File No: NTH19/00073/03
Your Ref: SSD 10300

**Re: Review of EIS for SSD10300 – Coffs Harbour Cultural and Civic Space
23-31 Gordon Street, Coffs Harbour**

I refer to your letter of email dated 26 September 2019 requesting comments from Roads and Maritime Services in relation to the Notice of Exhibition for the above-stated development proposal.

BUS PARKING AND DROP-OFF WILL OCCUR FROM GORDON ST, AS WILL DAY-TO-DAY DELIVERIES.

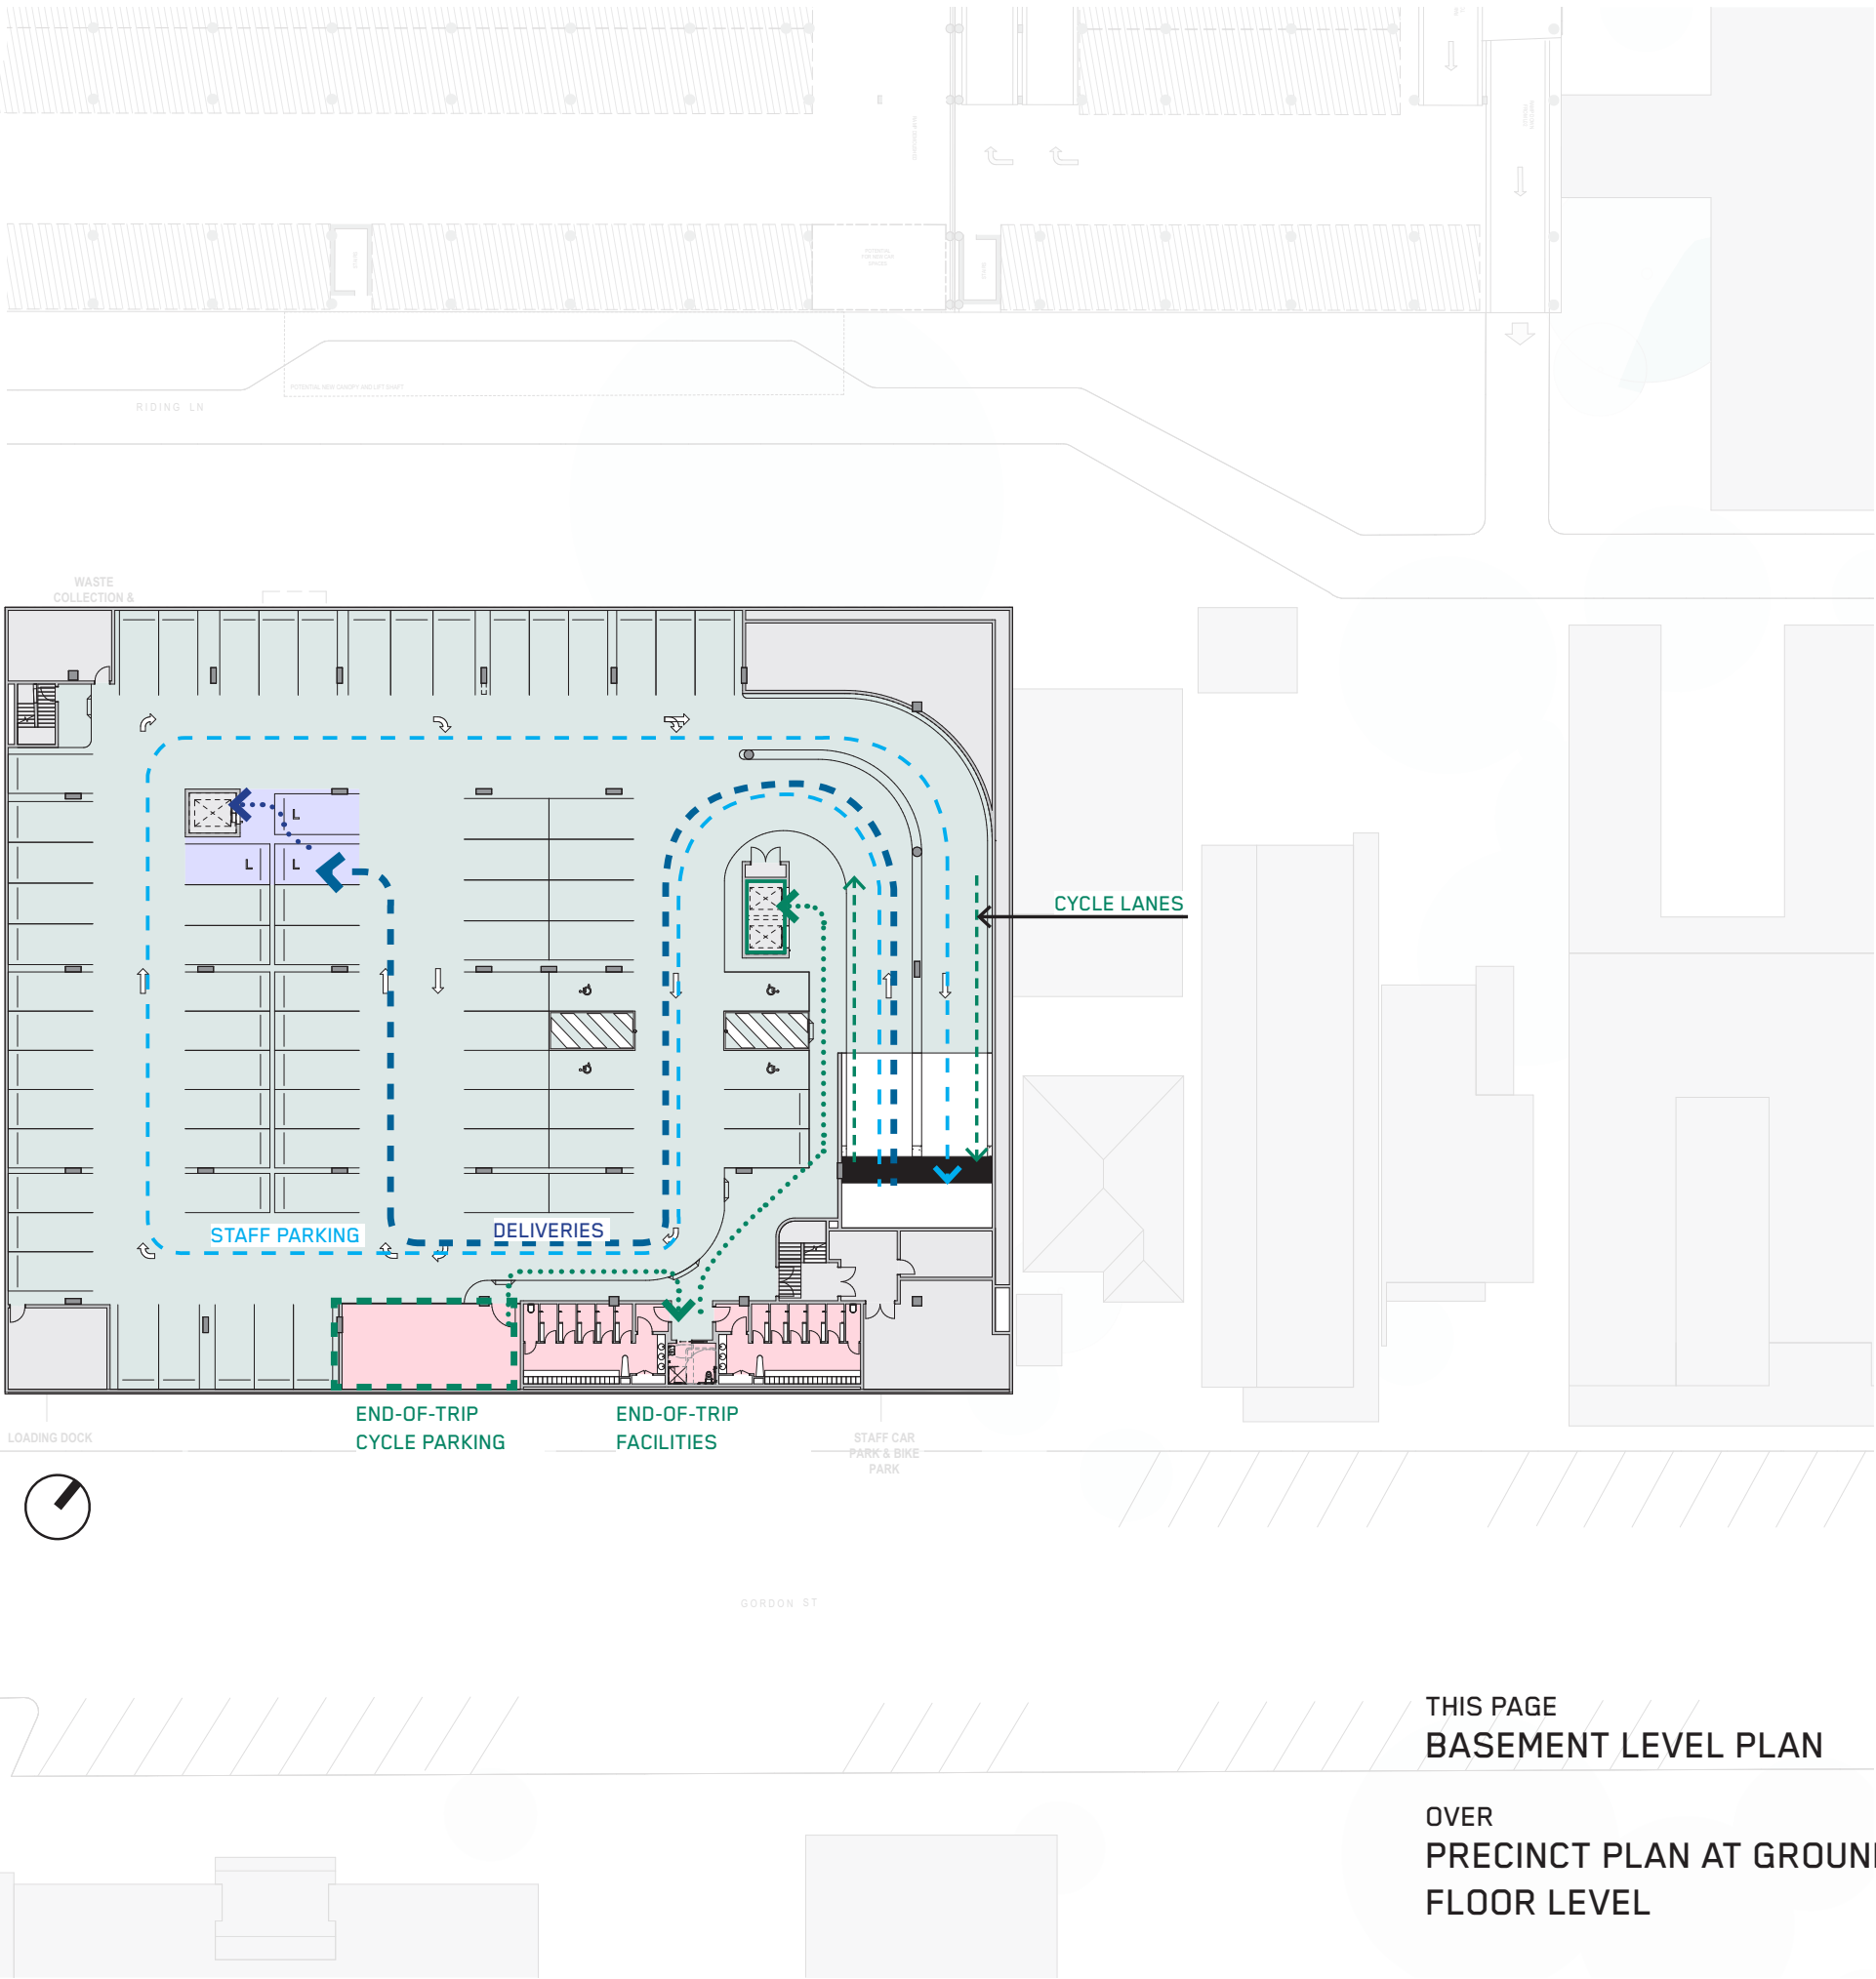
3. An on-street drop off/emergency vehicle parking area is proposed along the Gordon Street frontage. The emergency vehicle space does not appear to be long enough (10m?) to safely accommodate these vehicles. The other 5 spaces will have to be shared by the public, couriers and buses. These parallel spaces are 6m in length and therefore accessible only to smaller vehicles. This is a matter that Council or the Department may wish to further consider.

5. The internal service dock off Gordon Street will accommodate a large rigid truck. It will have to reverse back into the dock. This will require a Traffic Control Plan (TCP) and associated traffic control for each occurrence. It is suggested that this requirement be addressed in conditions of any approval.
